Re: Objection to MP08-0244 MOD 1 Modification Request for Mixed Used Development at 23-37 Lindfield Avenue and 11 Havilah Lane, Lindfield.

1 SHADOW DIAGRAM - 21stDEC_9AM
5003 SCALE1 : 650

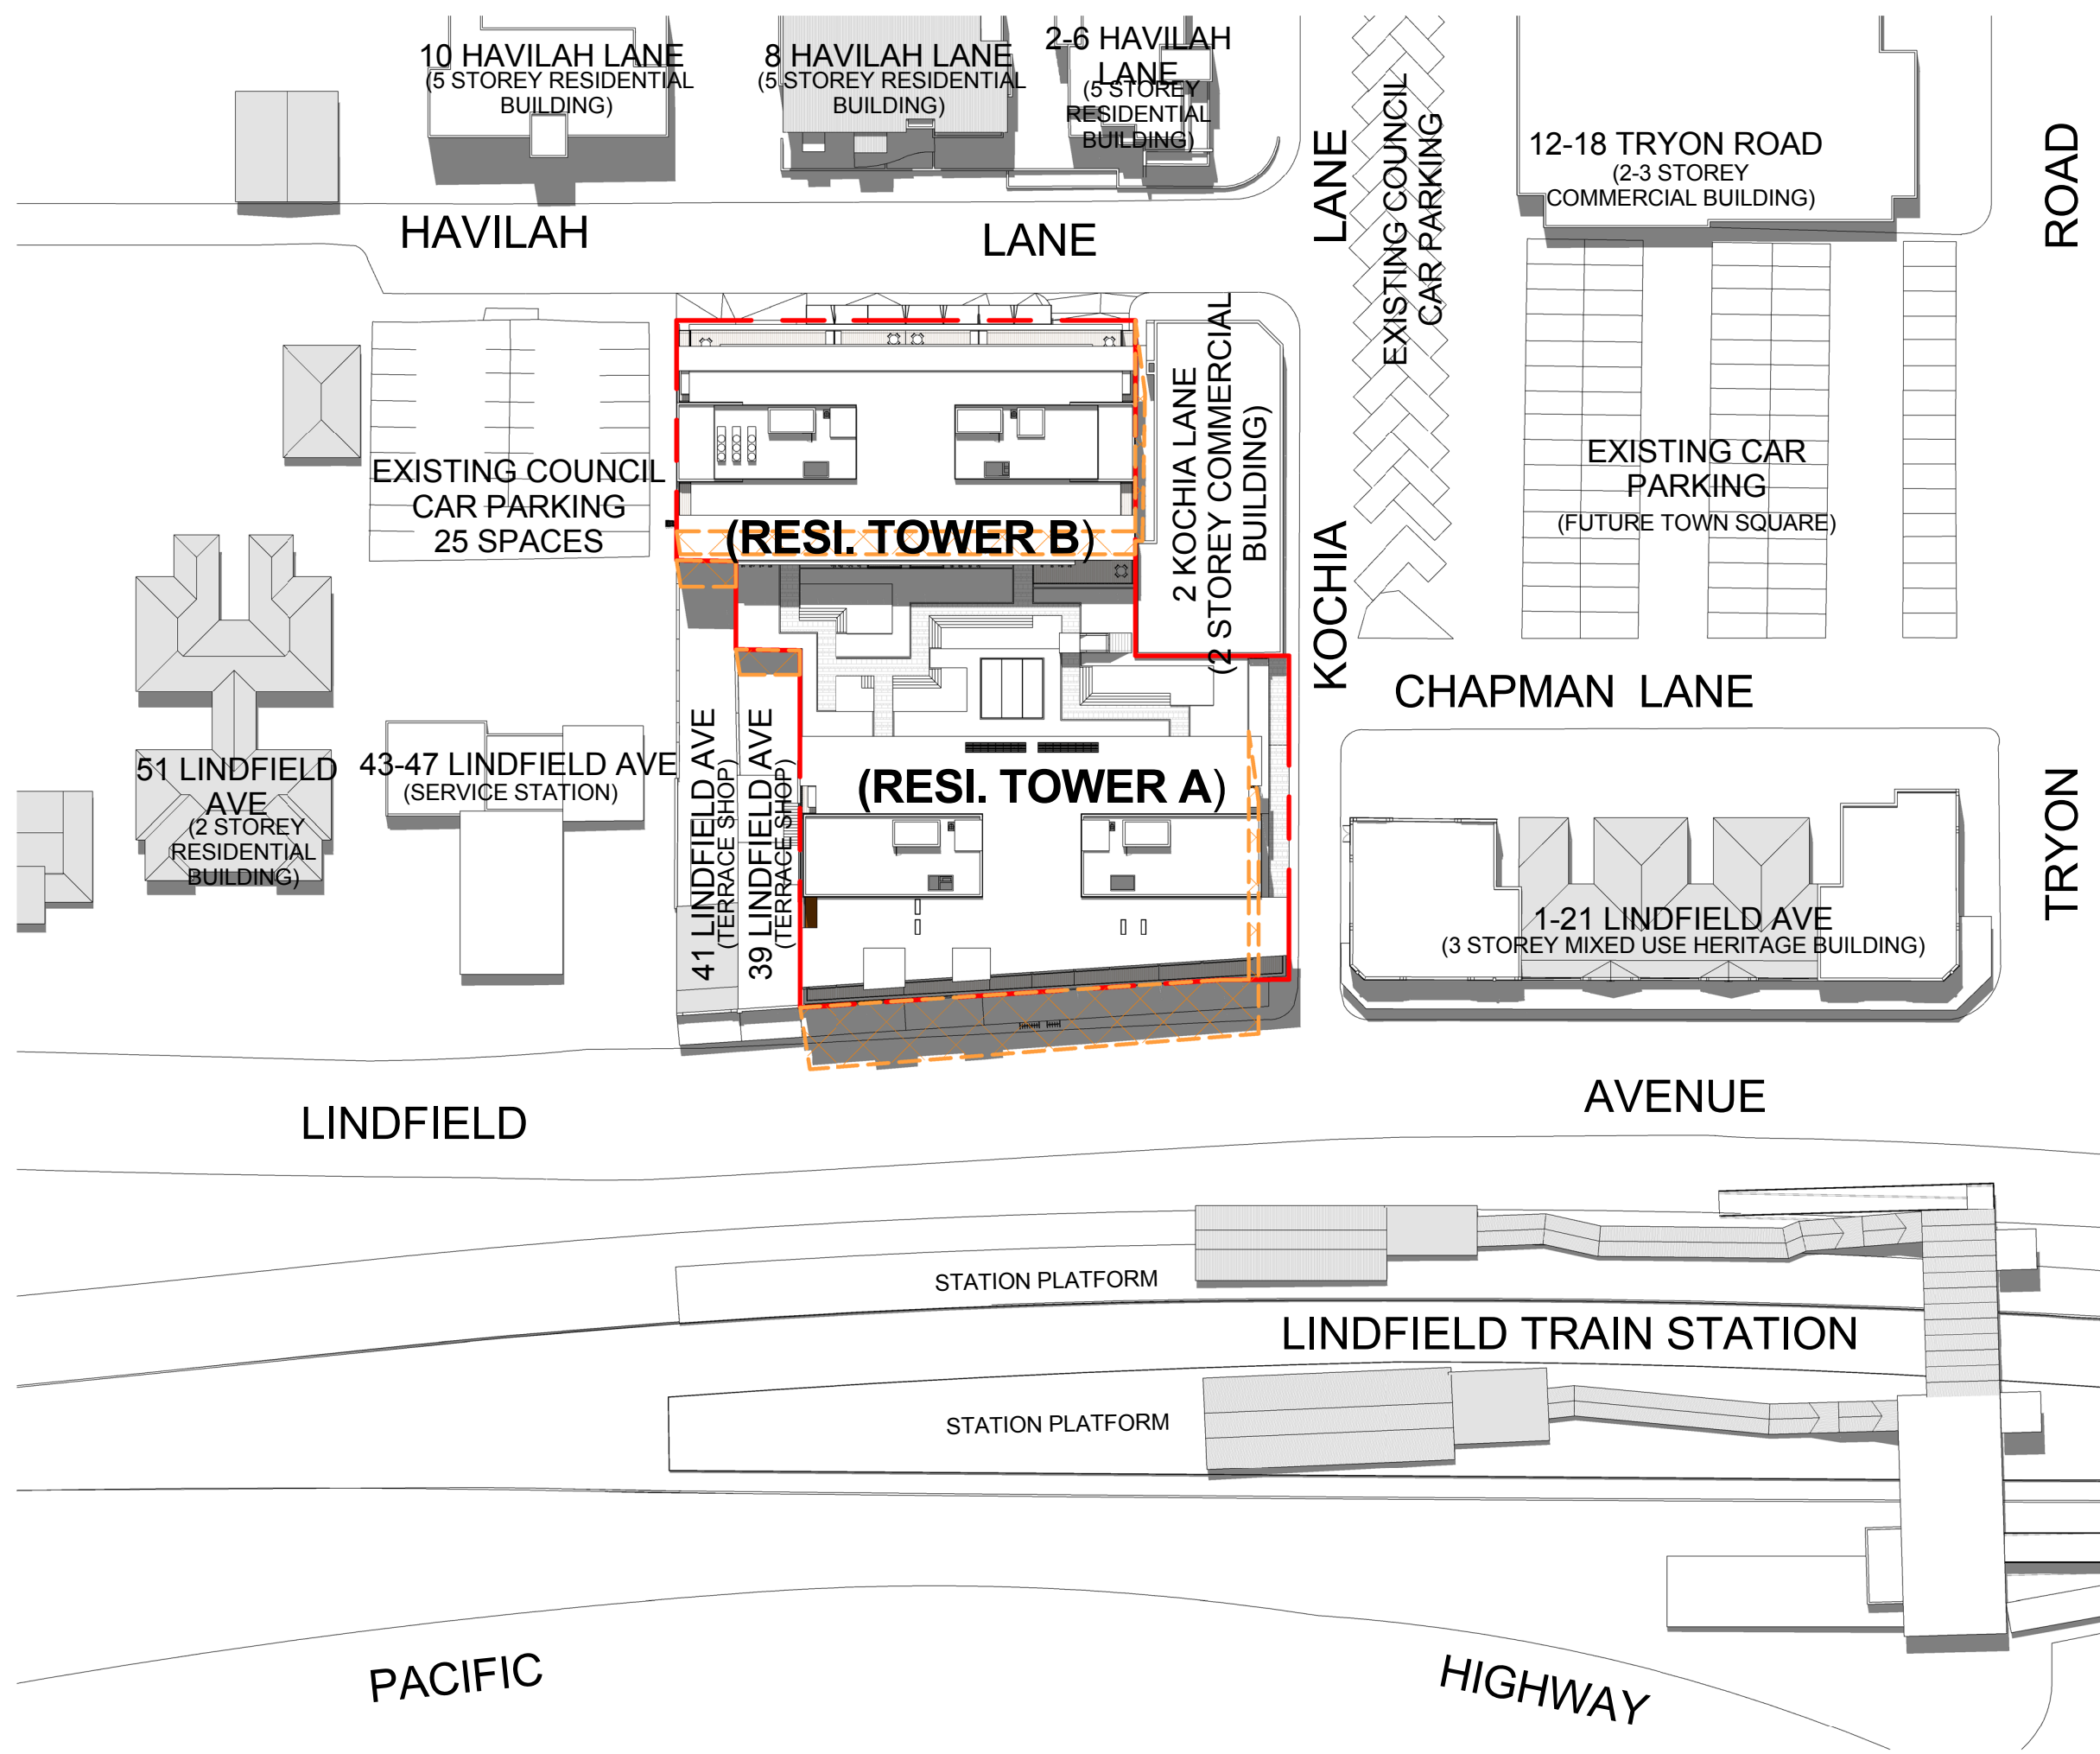
The additional storeys create new adverse shadowing: a) for residents of Havilah Lane apartments particularly after 3pm. B) for the shops surrounding the car park. c) shadowing will also occur for 75% of the year on the rail platform.
